1. New Primary School in Mulgoa Rise – 1-23 Forestwood Drive – Glenmore Park

ptc. has been engaged by Richard Crookes Construction on behalf of School Infrastructure NSW (SINSW) to address comments received following the submission of the State Significant Development Application (SSDA) and subsequent additional request for information for the proposed development of a new primary school located at 1-23 Forestwood Drive in Glenmore Park.

This letter has been prepared in response to the following documents:

Figure 3 – Raised Crossing Flood Impact Modelling

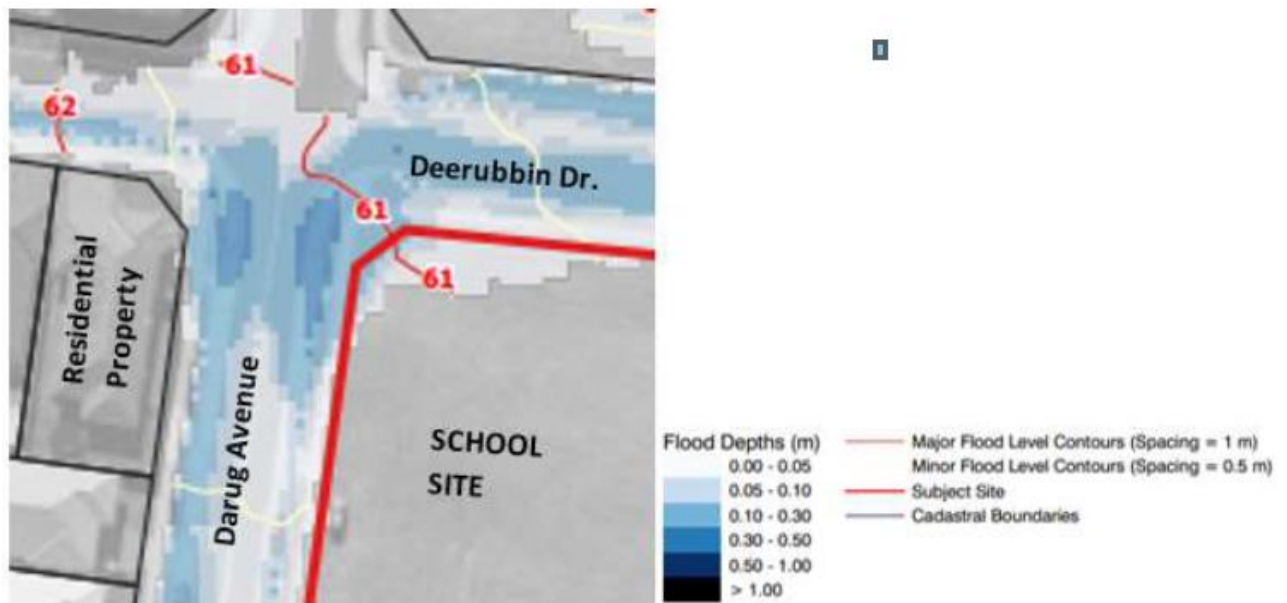
As per advice received from the project's civil engineer, blisters or raised crossings are not feasible due to potential flooding issues, please refer to the flooding assessment. The proposed solution is shown in Figure 1, with yellow lines representing fencing instead of kerb buildouts. The project is open to alternatives, such as bollards or other devices if these are seen as a better outcome. Refer to Section 3.1 for further comments and analysis.
